KIRKLEES METROPOLITAN COUNCIL INVESTMENT & REGENERATION SERVICE

DELEGATED DECISION TO DETERMINE PLANNING APPLICATIONS

Reference No:	2022/62/90952/W
Site Address:	52, Gledholt Road, Gledholt, Huddersfield, HD1 4HR
Description:	Alterations to dwelling to form House in Multiple Occupancy (HMO) comprising 8 bedrooms, demolition of outbuilding and boundary wall, formation of parking spaces and erection of replacement boundary wall and fence (within a Conservation Area).
Recommending Officer:	William Simcock

Officer Report 2022/90952 52 Gledholt Road HD1 4HR

Ground Floor  
1 : 50

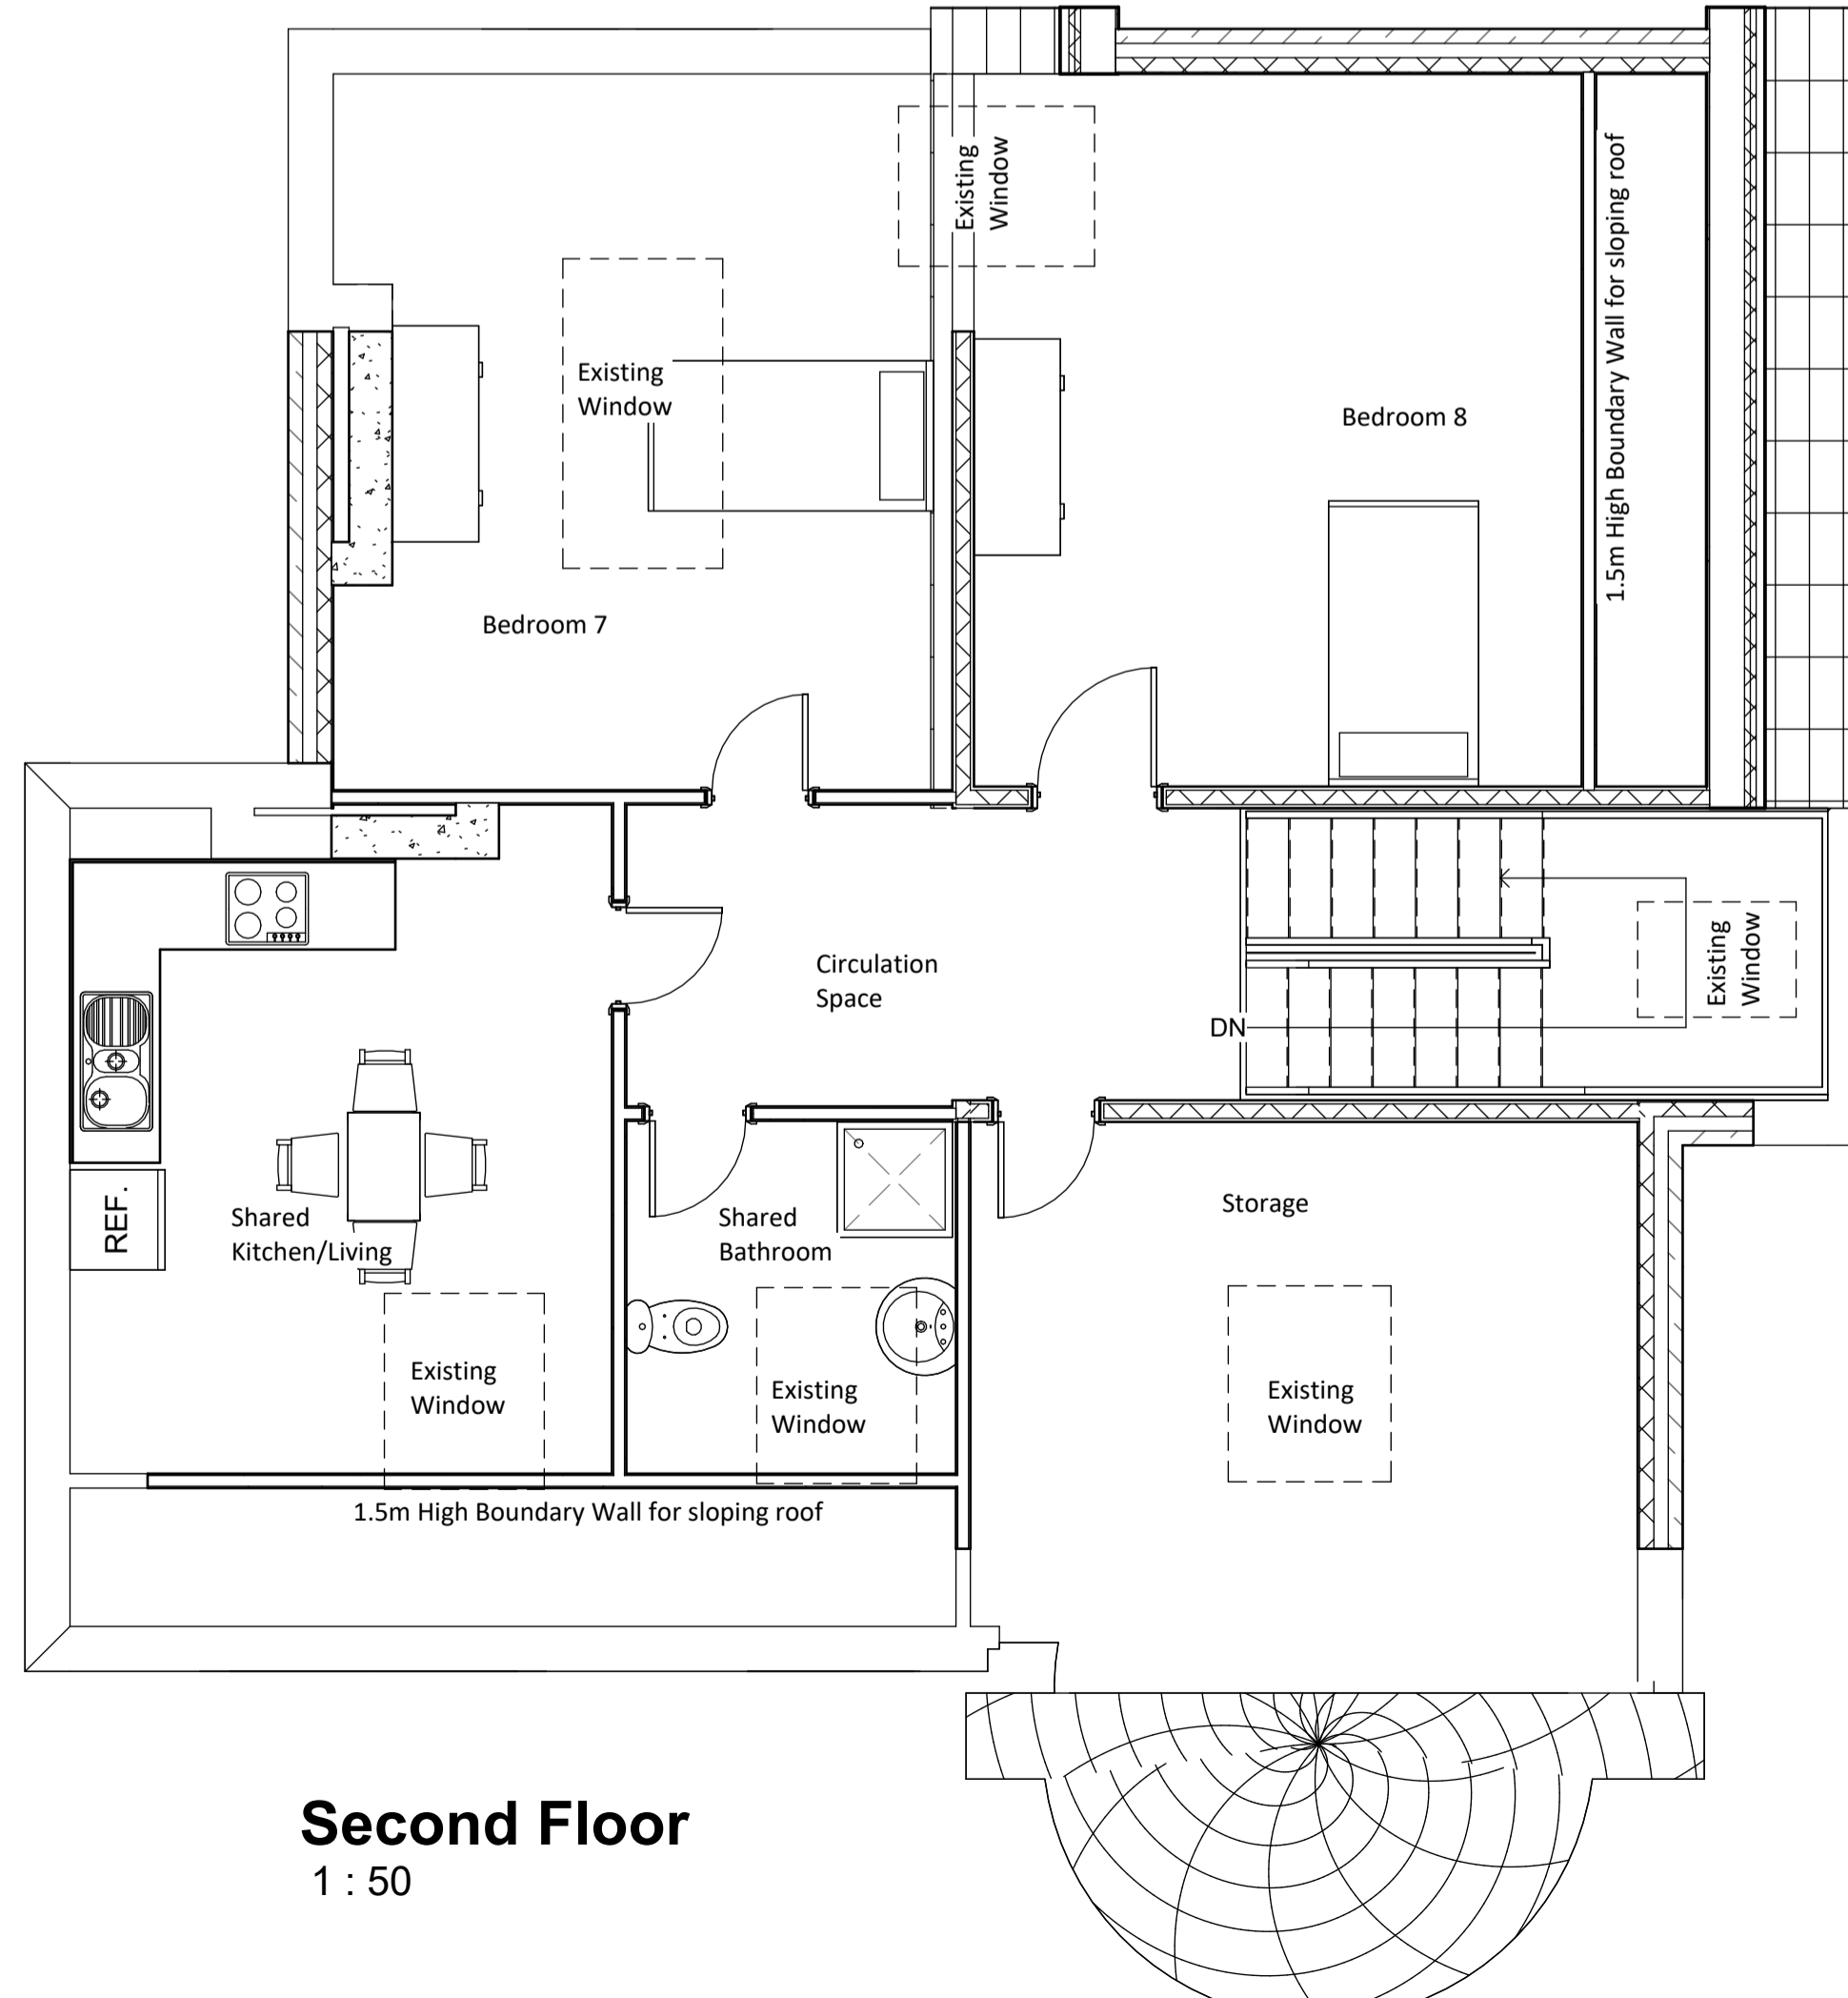
The earliest version of the plan which showed bedrooms in the basement would have been unacceptable because of limited light and outlook, and this has now been rectified – all bedrooms are at ground floor or above. Whilst outlook for the occupants of bedrooms 7&8 would be more limited than for the other rooms since they would be reliant on rooflights only, it is considered that they would receive adequate levels of natural light. The outlook for bedroom 4 would be over the car parking spaces (including one just beneath the window) but since the ground floor of the property is elevated compared the level of the proposed car park, it is considered that its outlook and ability to receive natural light would not be severely compromised. All bedrooms, including the second-floor or attic bedrooms, would be in excess of the minimum floorspace set out in the Nationally Described Space Standards. The occupants would be provided with what is considered to be an adequate amount of shared or communal space, comprising the basement rooms, main living room and kitchen at ground floor, the smaller shared kitchen / living room at the uppermost floor, and attic storage.
